Planning Application Ref: **AW/178/19/T**

Location: **106 Barrack Lane, Aldwick PO21 4EA**

Description of works: **Reduce crowns of 2 No. Oak trees by 1m & reduce crown of 1 No. Field Maple tree by 1m**

106 Barrack Lane

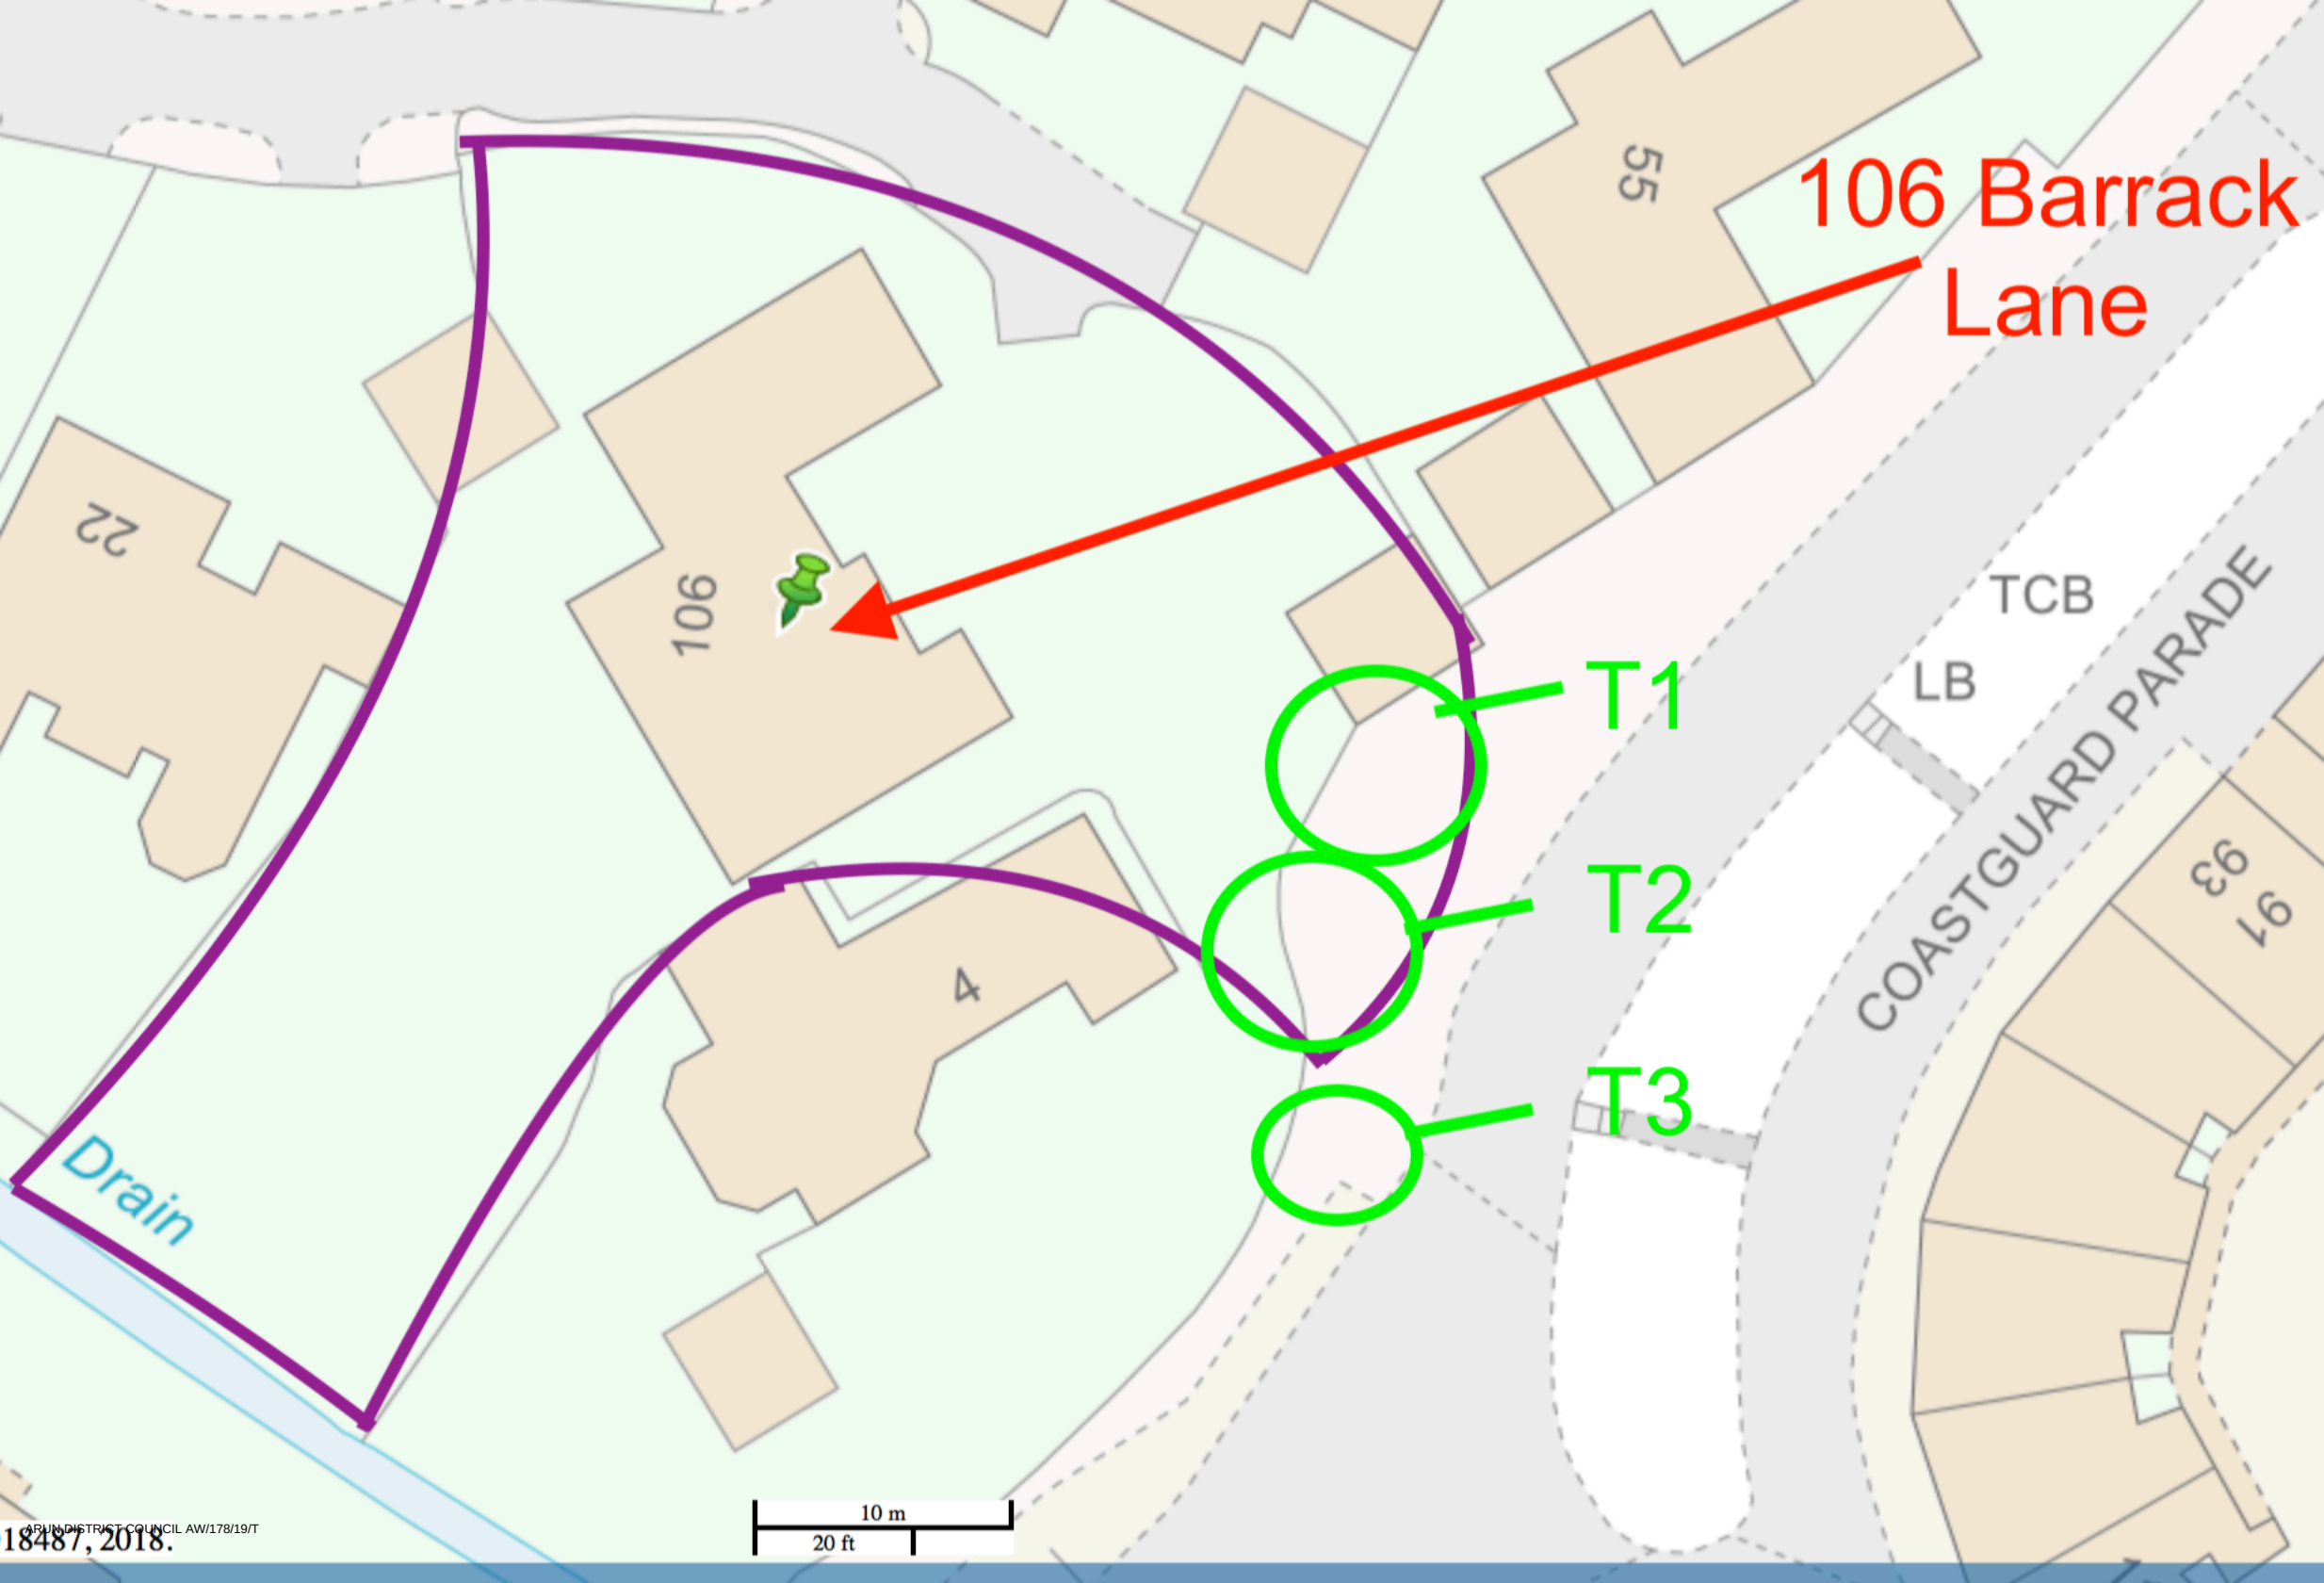
- Outwardly and from a distance these trees appear to be in a fine physiological state but with heavily modified or suppressed form.
- They grow to the front of the property effectively on roadside verge and are prominent. They are highly visible from the public highway (road, footway and commercial premises).
- T1 and T2 have been the subject of past crown modifications resulting in relatively small and compact limb/branch framework. This work was most recently undertaken late 2015/early 2016.
- T3 is a low quality specimen, having been suppressed by companion trees.

- T1 and T2 - Cyclical crown reduction work throughout the remaining life-span of these trees will be necessary to achieve a degree of structural integrity appropriate for their location.
- T1 and T2 - There is insufficient extension of new growth (1-1.5m) since the last major pruning operation (c2015/16); so that repeat crown reduction at this time (or within the next 18months) would be too early in the management cycle and likely have a negative effect on their long-term vitality.
- While T1 and T2 undoubtedly cast some shade over the property for part of the day this has not been established as excessive so as to be a blight on the same.
- T3 - Field maple is not the subject of any Order (TPO) nor does it reside within Conservation Area, therefore the consent of the local planning authority is not required before undertaking any work to this tree.

- I recommend **REFUSAL** for this application.
